**RE: Sonata Unit 4 Trails Apartments  
Tracts 1, 2, and 3, The Trails Unit 4  
Third DRB Submittal**

RESPEC, agent for Sonata Trails, LLC, owner of the above referenced property, is requesting approval from the Development Review Board (DRB) on this Site Development Plan submitted for your consideration. This is the second submittal to the DRB for this project. The first hearing was held on June 3, 2020. Below is a response to comments received at the first DRB meeting.

SHEET TITLE:  
**CONCEPTUAL OVERALL UTILITY PLAN**

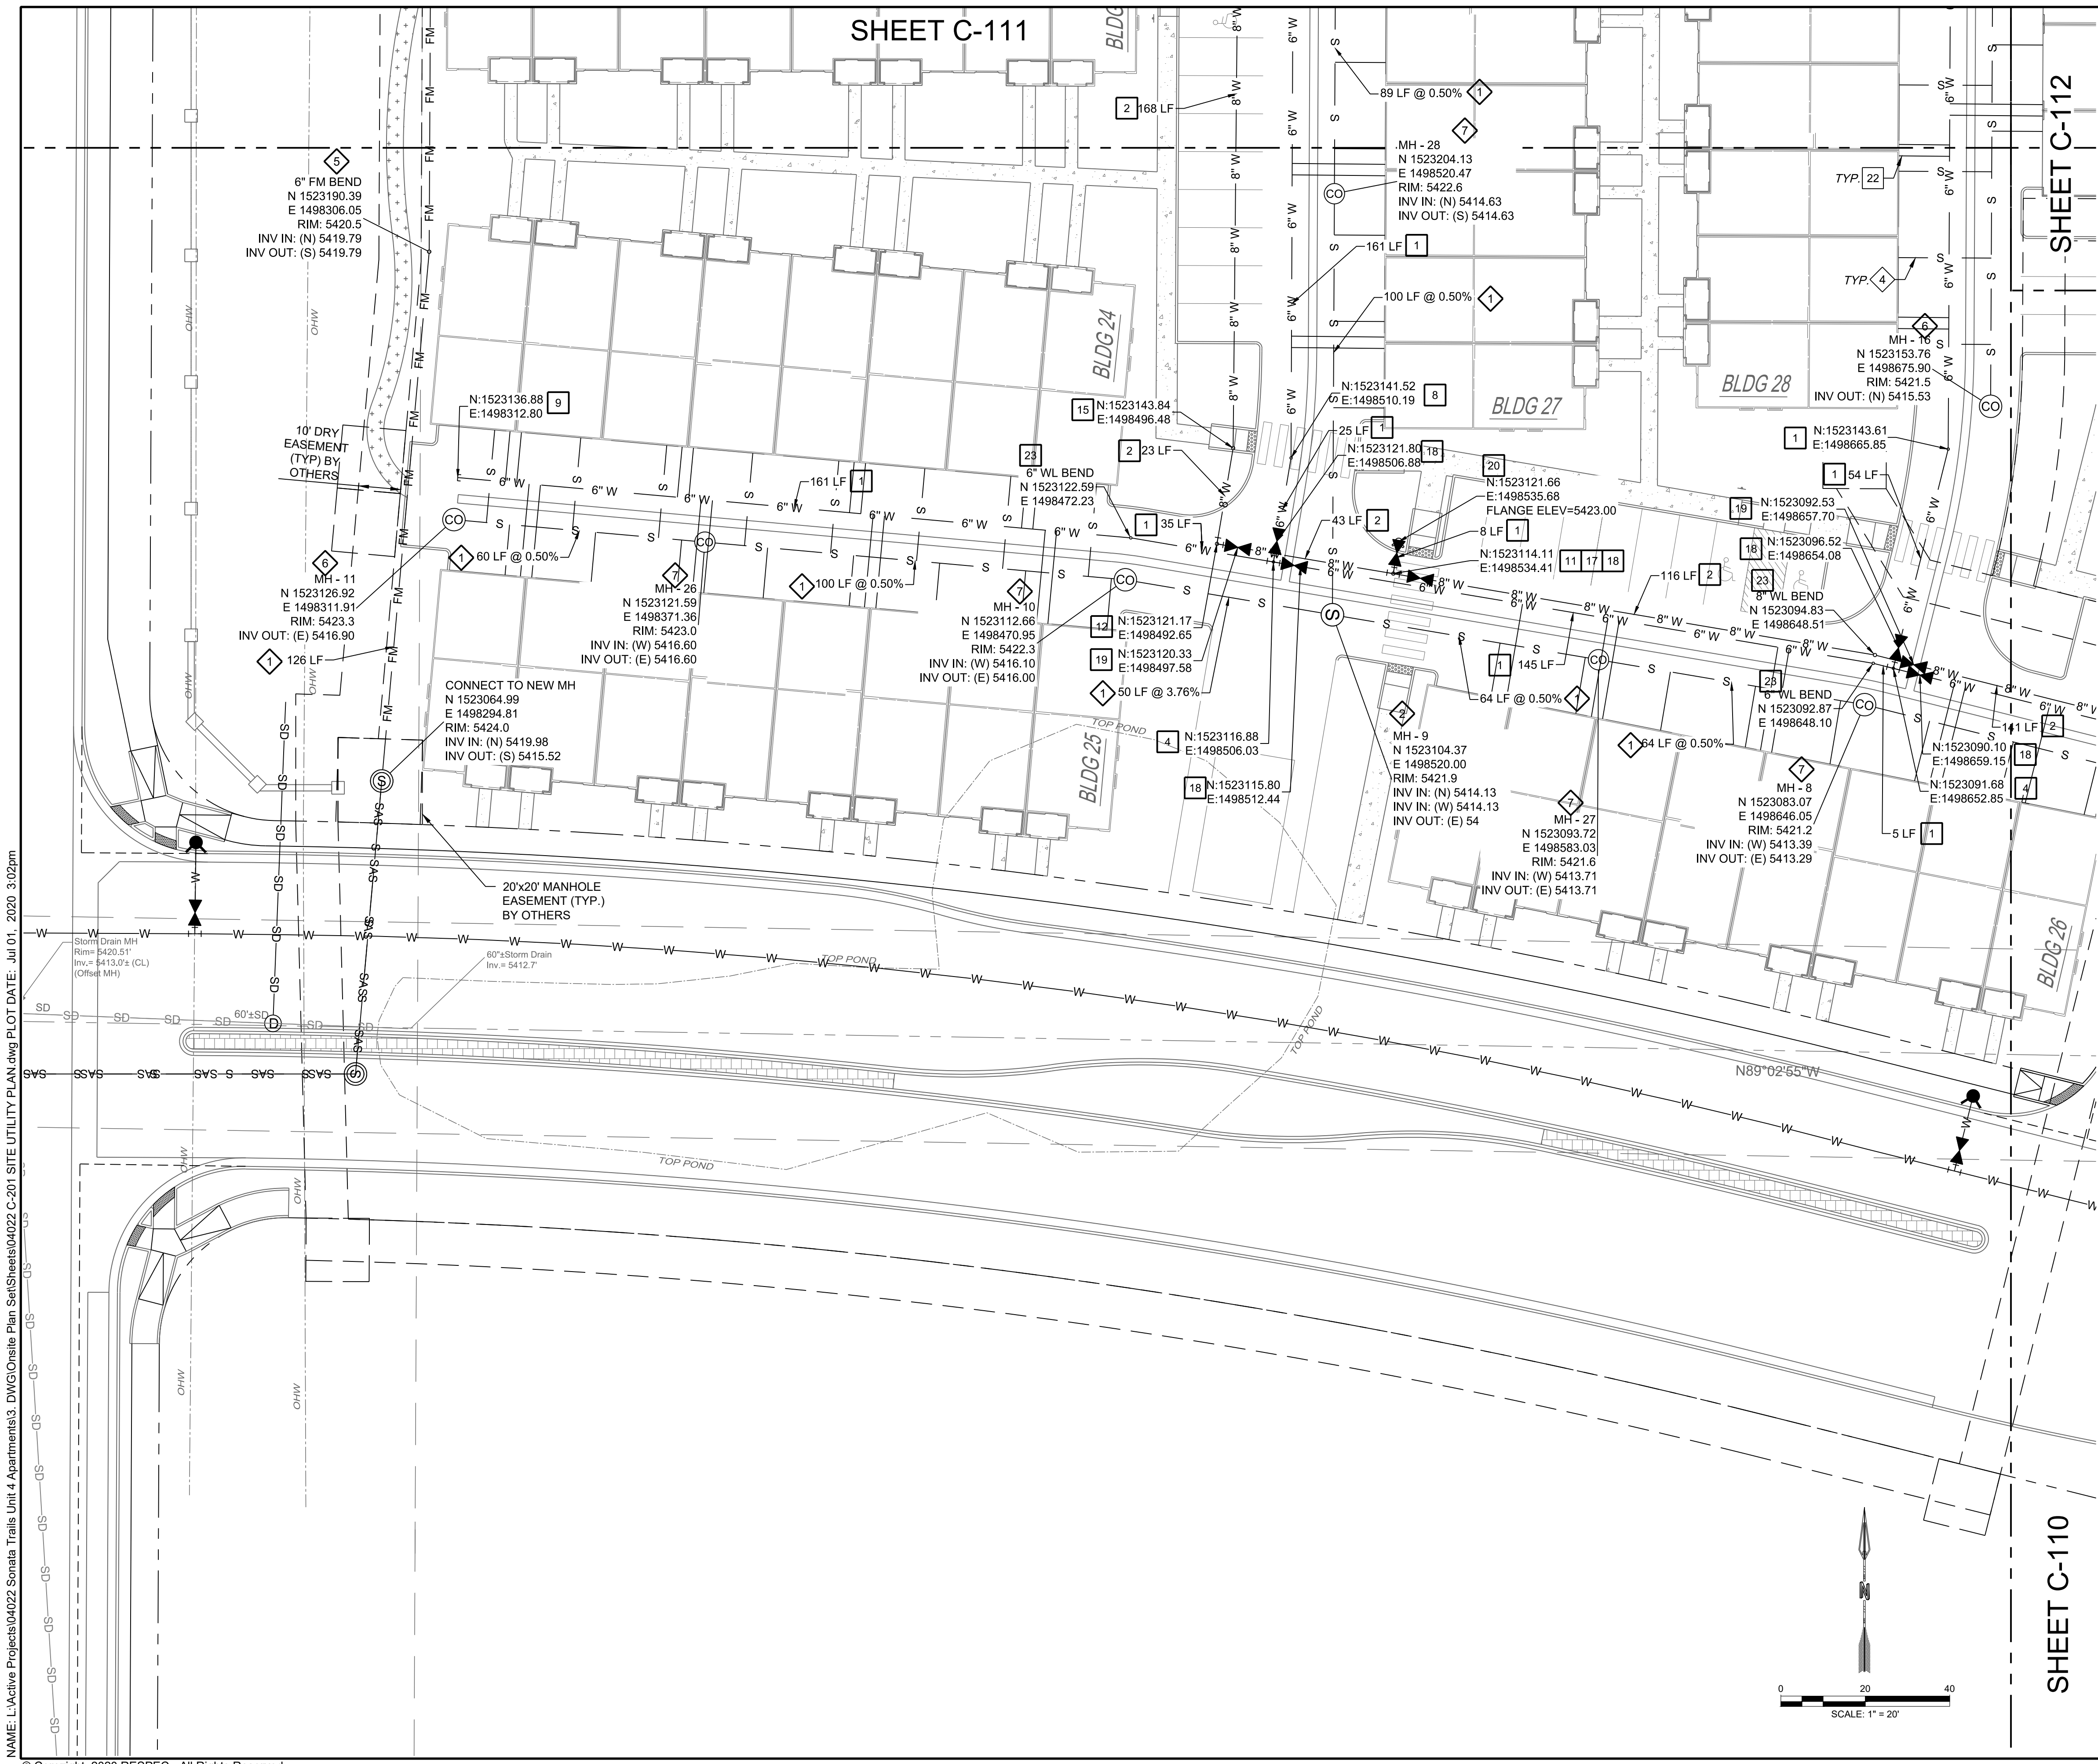
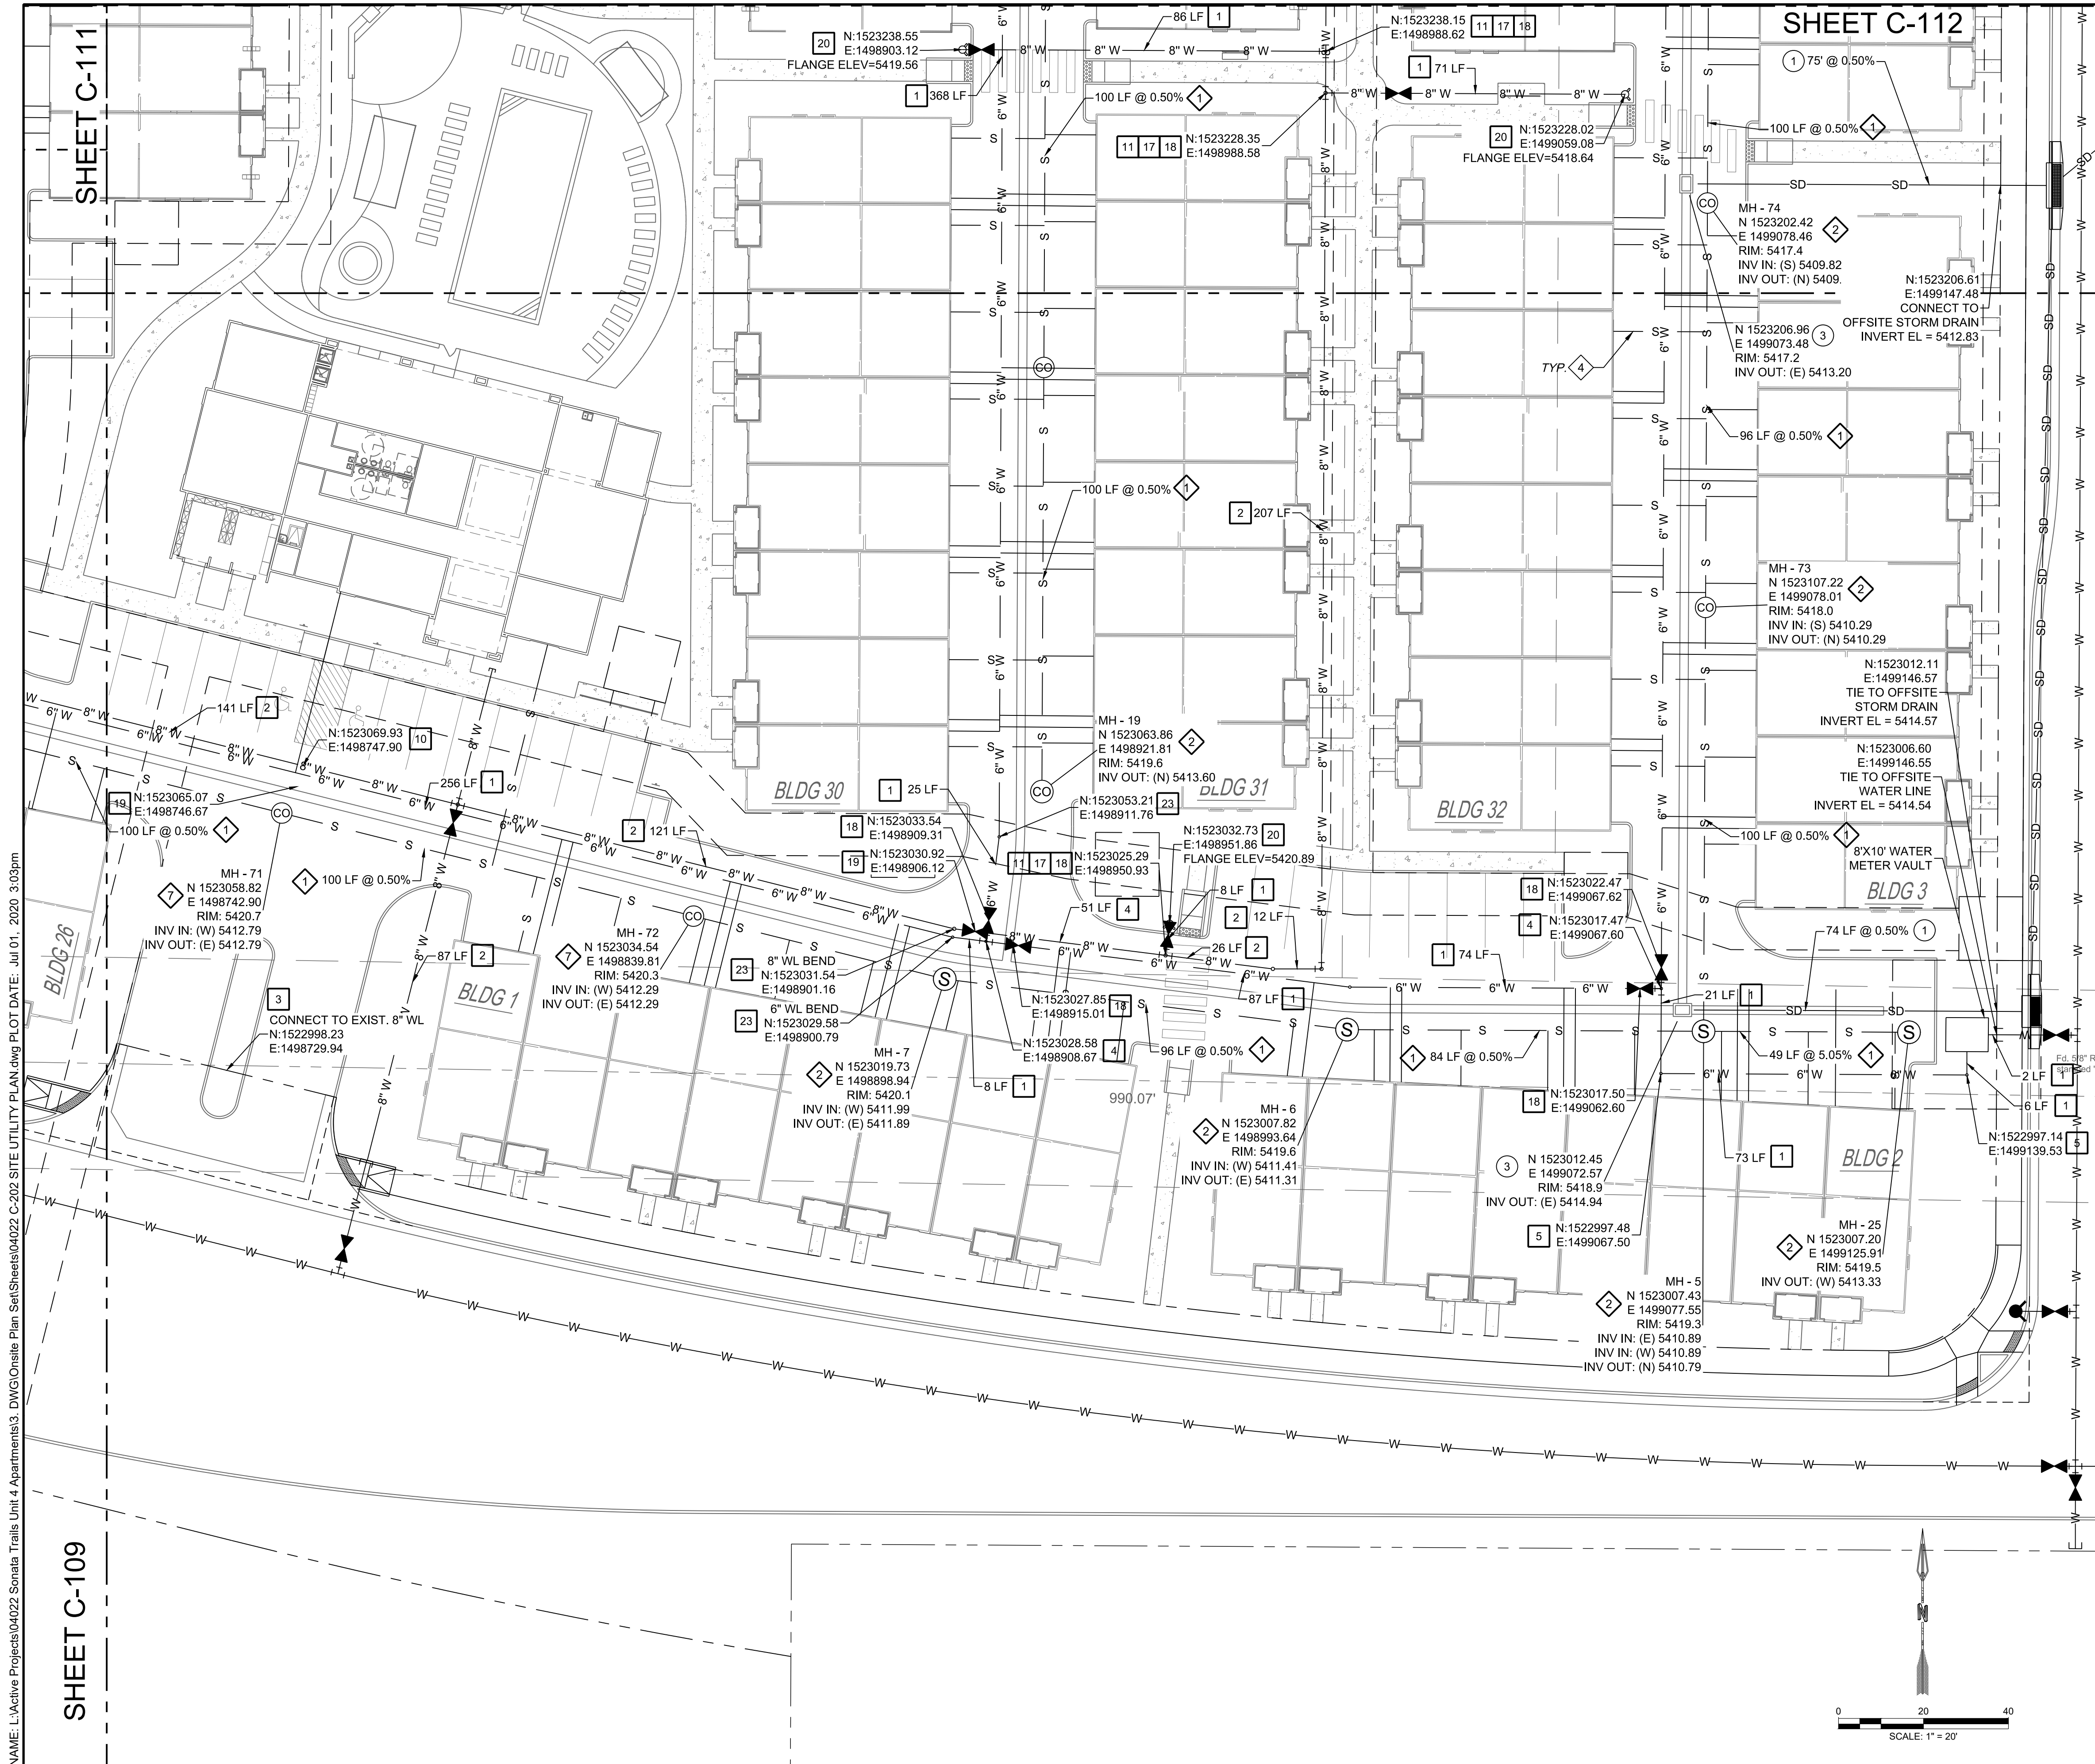
1. The development is outside of the Adopted Service Area. Water Authority Board approval is required prior to Site Plan approval. This will be in the form of a development agreement. The development agreement shall be supplemented by a serviceability letter.
2. A request for availability was received. Serviceability Letter #200426 is currently being researched.
  - a. The official requirements will be stated in the serviceability letter.
3. Utility Plan
  - a. Sanitary sewer
    - i. Construct dry sanitary sewer lines along portion of Treeline Ave. (just enough to provide Tract 3 to the south service) and the entire length of Chatsworth Dr. Label these on the utility plan accordingly.
      1. This shall be reflected on the infrastructure list.
      2. This shall be designed to facilitate future discharge to the future 15" sanitary sewer interceptor.

- ii. The dry sanitary sewer along Oakridge St. can be a deferred item since the roadway will not be constructed at this time. Label this on the utility plan accordingly.
  1. This shall be reflected on the infrastructure list.
  2. This shall be designed to facilitate future discharge to the future 15" sanitary sewer interceptor.

- iii. Construct the public sanitary sewer along Treeline Ave. just enough for a perpendicular service connection.
  - 1. This shall be reflected on the infrastructure list.

- 2. Please confirm if the proposed manhole south of existing manhole C10302 can be eliminated by extending east directly from the existing manhole along Treeline Ave.

- iv. A proposed lift station is shown at the northeast corner of the subject development which ultimately discharges to proposed public gravity sanitary sewer along Treeline Ave. at the southwest corner of the development.

- 1. Considering the potential interim condition with the private lift station, the Utility Plan should show the phases.
    - a. The interim use of a private lift station and the trigger to eliminate the private lift station and discharge to public sanitary sewer that flows to the proposed interceptor along Paseo Del Norte/Avenida De Jaimito when it is available may need to be detailed in the development agreement.

- v. Label proposed lift station and onsite sanitary sewer as private (both force main and gravity sewer).
- / Proposed lift station and onsite sanitary sewer has been labeled as private. See revised utility sheets.

- b. Water
    - i. Differentiate public waterline and private waterline onsite.
- / Labels have been added to differentiate between private and public waterlines. See revised utility sheets.

- ii. Public waterline needs to be shown along Treeline Ave., Chatsworth Dr. and Oakridge St. frontages. Also, an onsite public waterline shall be provided to provide a looped waterline connection. This shall be in an alignment that provides access for maintenance and operation.

- iii. The public waterline along Oakridge St. can be a deferred item since the roadway will not be constructed at this time. Label this on the utility plan accordingly.

/ Dry sanitary sewer added along a portion of Tree Line Ave to serve Tract 3. This is shown on the plan and on the infrastructure list. General Note 13 states that "all utility improvements located within the right-of-way are public." General Note 14 states that "all utilities shown located within the private property shall be private unless otherwise noted." Labels have also been added as well to differentiate between private and public infrastructure. See revised utility sheets and infrastructure list.

/ As you are aware, we are working with transportation and their request to construct our entire roadway frontage surrounding the development. No change has been made

- / Public sanitary sewer along Tree Line Ave for a service connection has been provided and shown on the plan and infrastructure list. The proposed manhole has been eliminated and a tee/wye connection is being proposed. See revised utility sheets and infrastructure list.

- / Public waterline is provided and shown in Tree Line, Chatsworth, and onsite. Water will be shown at the northeast corner and Oak Ridge once further direction is received from Transportation. See revised utility sheets.

- / No change has been made at this time pending determination on how to proceed with this area from Transportation.
